## Engineers Comments Regarding Surface Water Drainage

| <b>Application Reference:</b>   | LU/185/25/DOC                                                                                                                                                                                                                                                                                                                                                                                                                                                         | <b>Reviewer Reference:</b> | ADC/EXT2/D2134/83 |
| <b>Site Name:</b>               | Land West of Holly Drive Littlehampton                                                                                                                                                                                                                                                                                                                                                                                                                                |                            |                   |
| <b>Application Description:</b> | Approval of details reserv

SCALE AT A1:	DATE:	DRAWN:	CHECKED:	APPROVED:
1:250	27.06.2025	SRV	VPI	VPI
PROJECT NO:	DRAWING NO:	REVISION:		
519	519.1.VCE.0501	T3

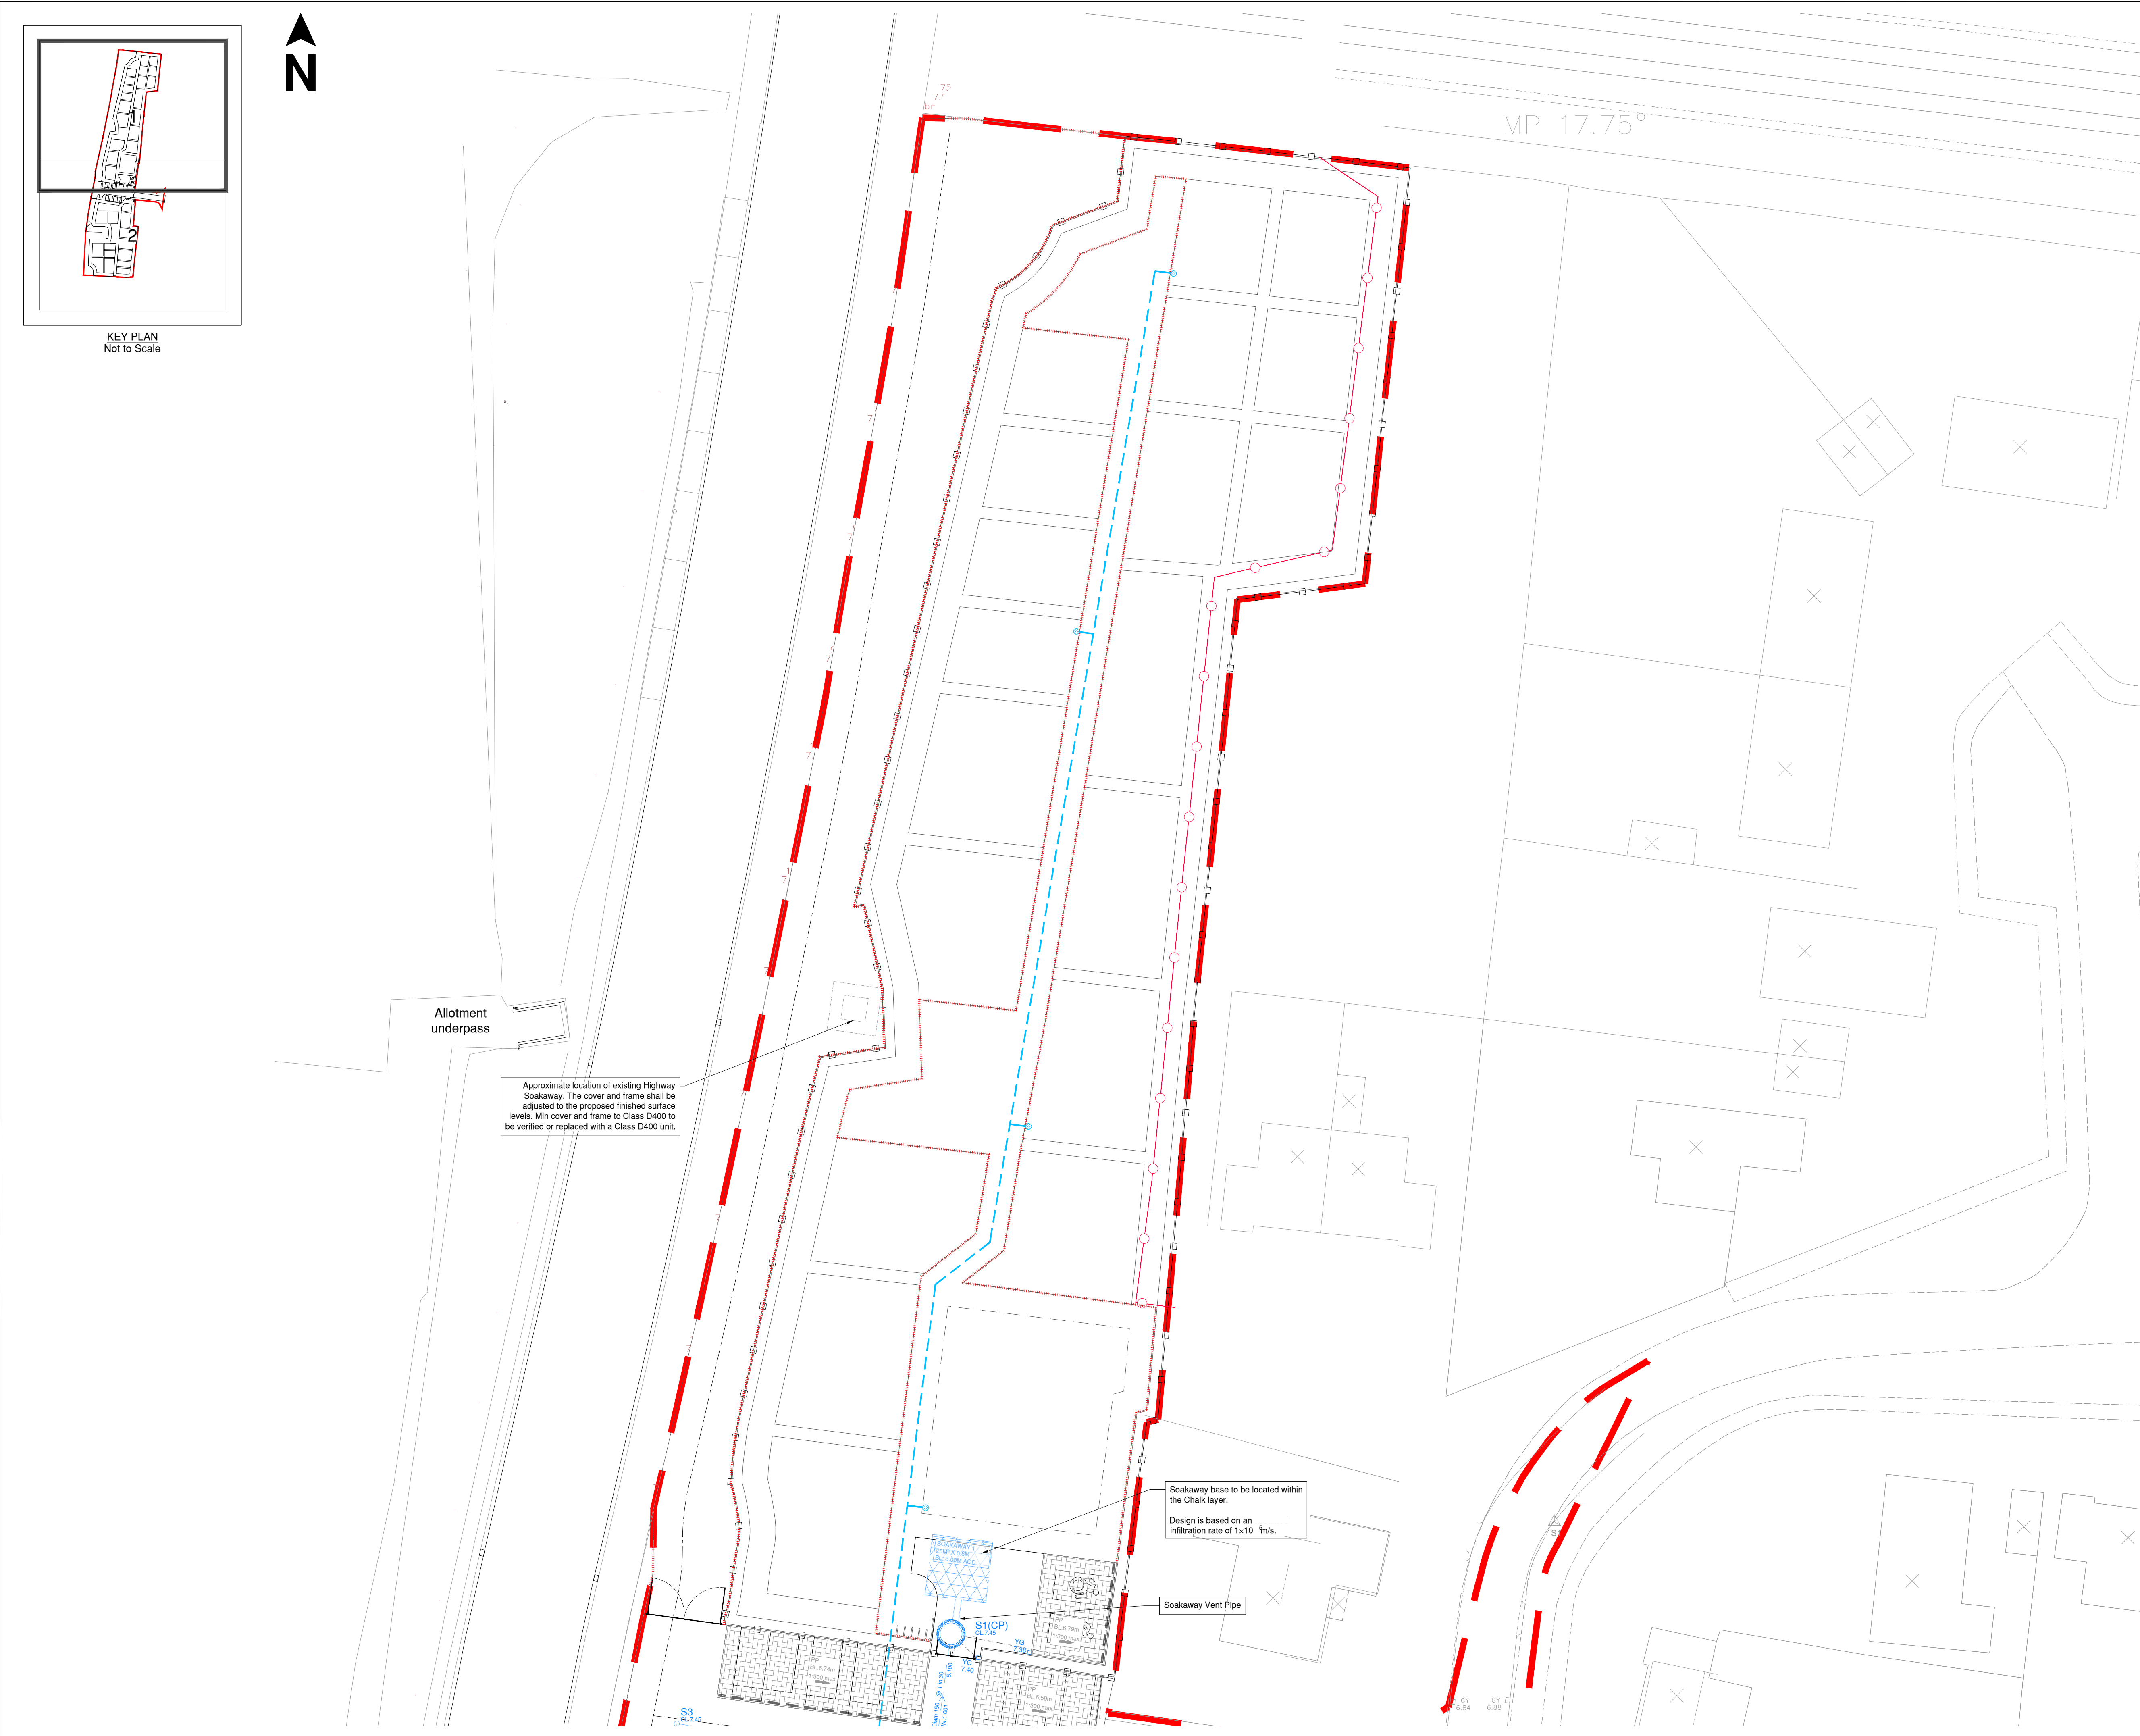
| 12 | Cellular storage criteria does not match drainage plan and details sheet 2 size. This must also correlate with the supplier product being specified.                                                      | The cellular storage detail shown on drawing <b>519.1.VCE.0506</b> and the domestic drainage layout on drawing <b>519.1.VCE.0501</b> are consistent with the accompanying drainage calculations. The specified size accords with the manufacturer's data sheets provided. | Comment closed. |  |  |
